**WELWYN HATFIELD BOROUGH COUNCIL
EXECUTIVE DIRECTOR - PLANNING, PUBLIC PROTECTION AND GOVERNANCE**

DELEGATED APPLICATION

Application No: 6/2019/0882/OUTLINE
Location: Colesdale Farm Northaw Road West Northaw Potters Bar EN6 4QZ
Proposal: Outline permission for residential development of site of up to 38 dwellings following demolition of the existing buildings and structures with all matters reserved apart from access
Officer: Mrs Elizabeth Aston
Recommendation: Refused

DRAWING TITLE: ACCESS DESIGN AND VISIBILITY SPY DRAWING

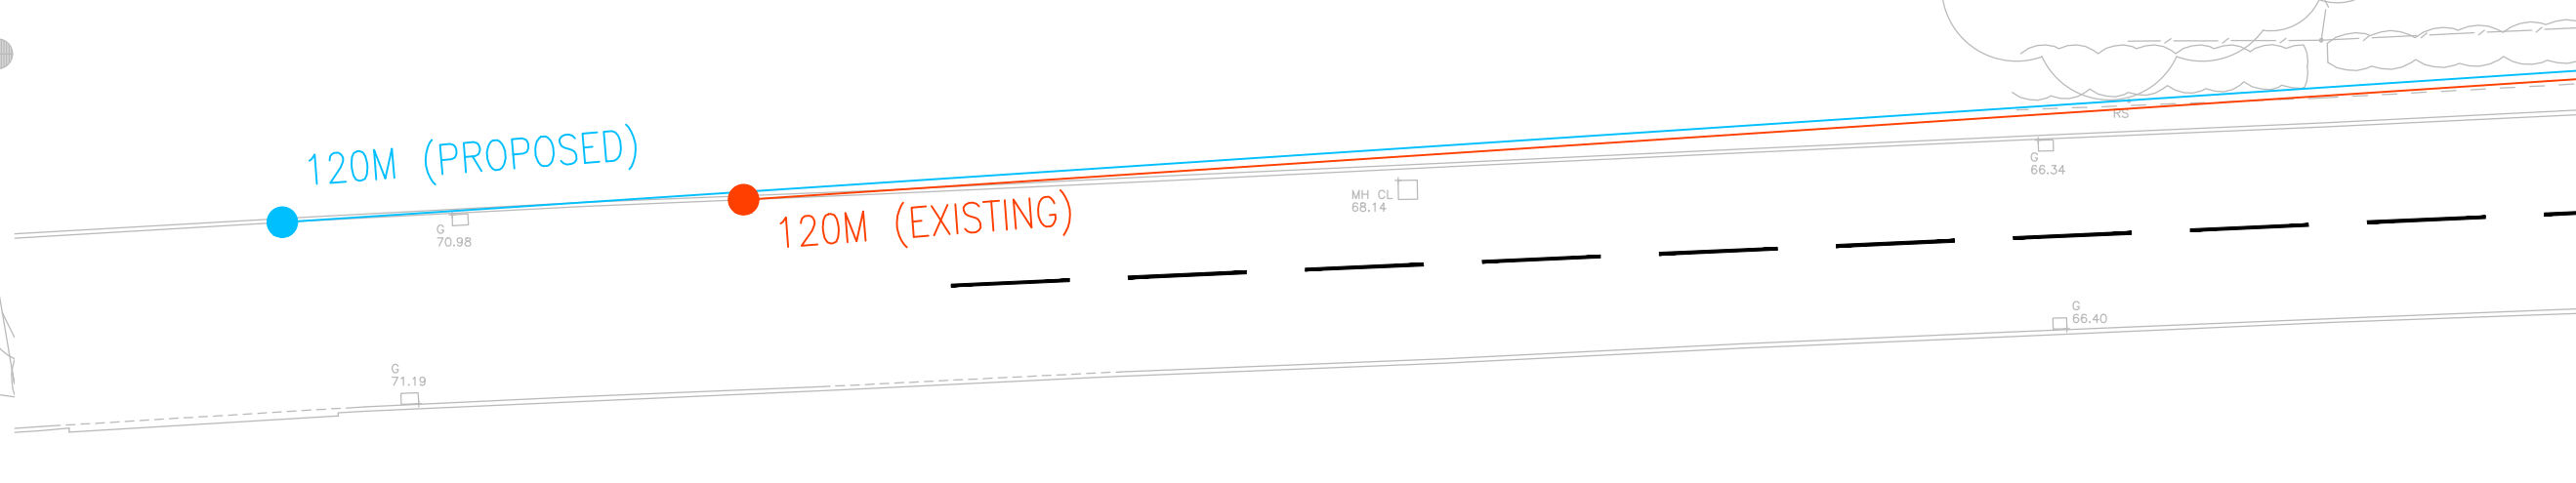
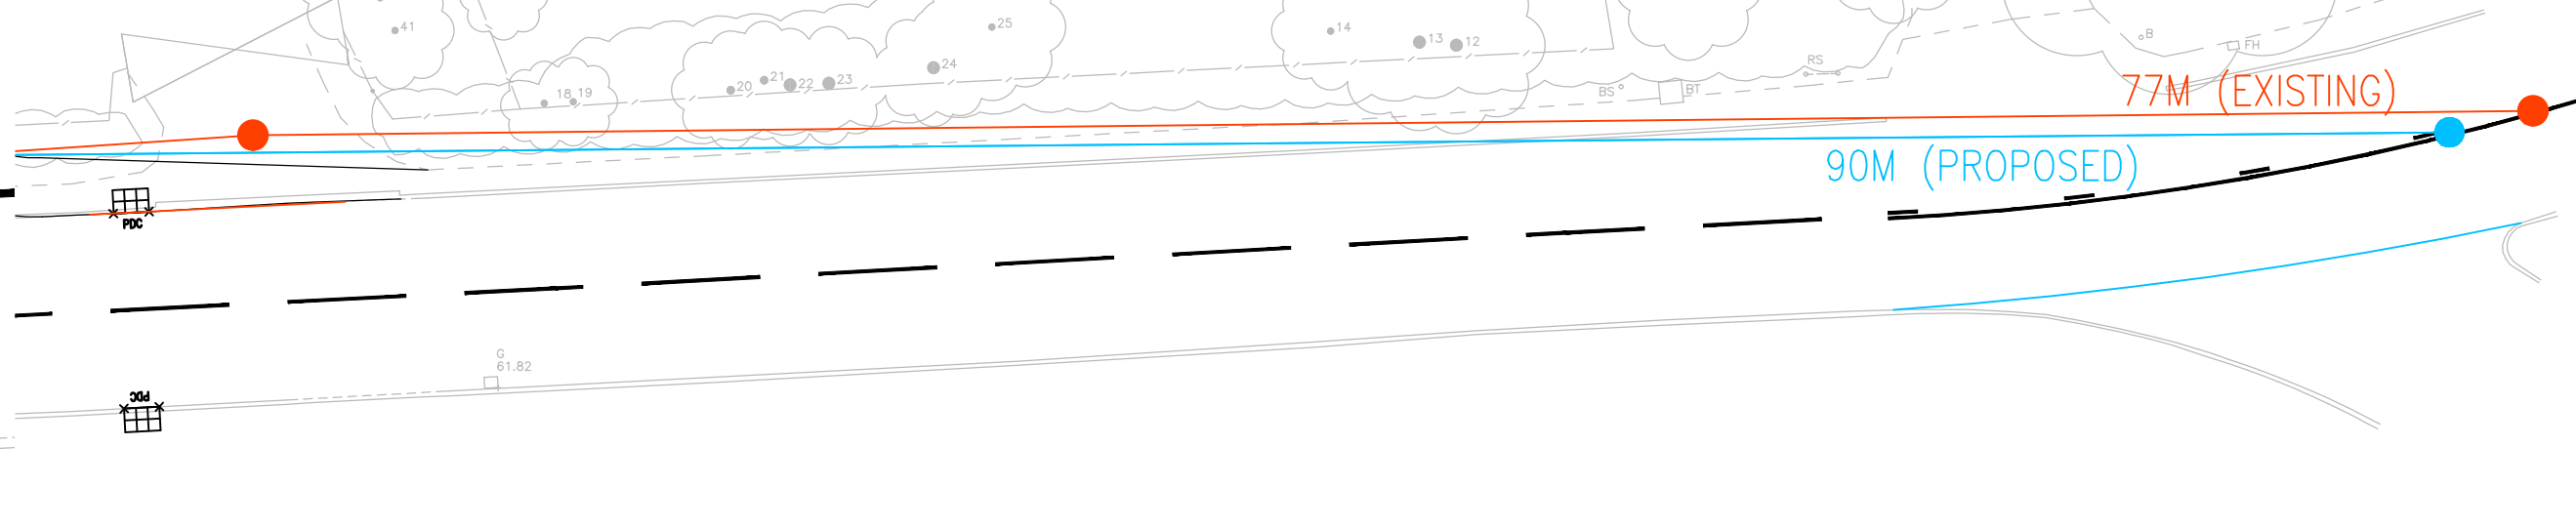
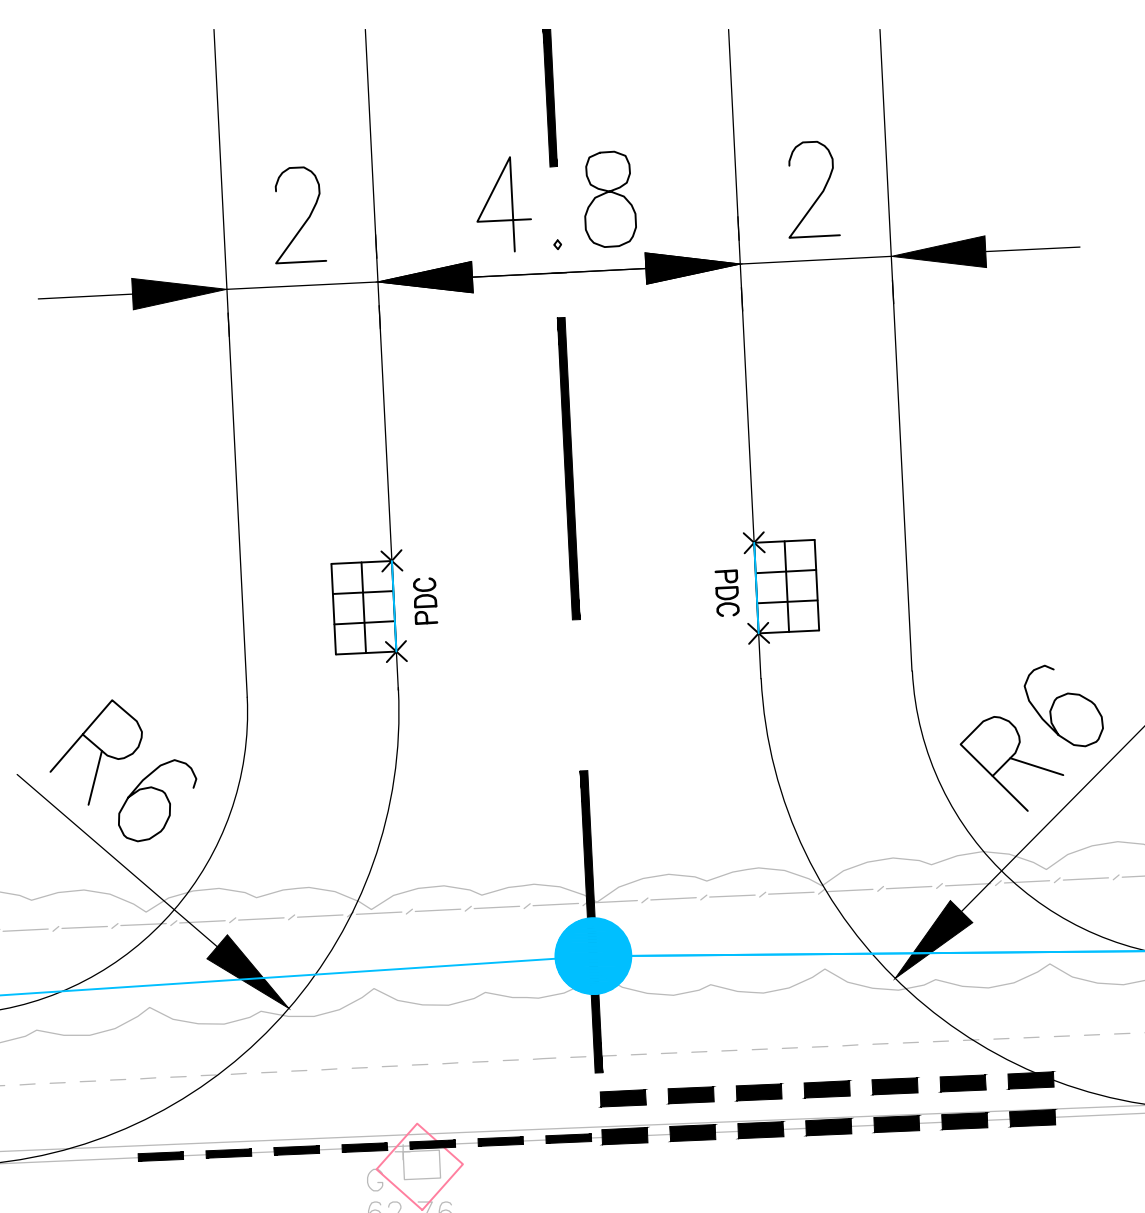
<p>Highways and parking</p>	<p>Following the submission of additional information and amendments to the proposed access design and visibility splays for the new access, County Highways have raised no objection to the application. They have commented that the impact of the changes of the level of vehicle trips generated by the development would be imperceptible within existing daily flows on the network. The amended Transport Statement (TS) has clarified that the existing eastern access to the site is to be retained and would be used solely for use by the existing Colesdale Farm. Whilst it is recognised that visibility from this access is beneath which the Highway Authority would require for new or amended accesses, due to the less intensive use of the access (when compared to its existing level of use) and provided that the use of the access is restricted to the existing farm only, County Highways have raised no objection to the retention of this access.</p> <p>The existing western access is proposed to be repositioned further to the west by around 15 metres and this access would provide vehicular access to the proposed residential development. The applicant has demonstrated on amended drawing ref. 24794-08-020-01 Rev B that visibility splays of 120 metres in a westerly direction and 90 metres in an easterly direction can be achieved from the proposed access, and County Highways are satisfied within this.</p> <p>As set out above in the section of this report on accessibility to services and facilities, County Highways have raised no objection to the application on sustainability grounds.</p> <p>Whilst the concerns raised by third parties in respect of traffic generation and proximity to the junction with Cattlegate Road are noted,</p>

<p>having regard to the considerations of County Highways the proposal is unlikely to result in an unacceptable impact on highway safety nor would the impact of the development on road network be severe.</p> <p>The Council's Parking Service has commented that whilst the proposal complies with parking standards, the layout of parking spaces as shown on the submitted indicative layout plan is not realistic and is likely to result in people parking in other location which are likely to be obstructive to other road users. As set out previously in this report, this is an outline application with all matters reserved apart from access. The layout of the proposed development is therefore a reserved matter, however it is considered that there is sufficient space within the site to enable alternative parking layouts to be considered which may address the concerns raised in respect of the location of parking spaces.</p>
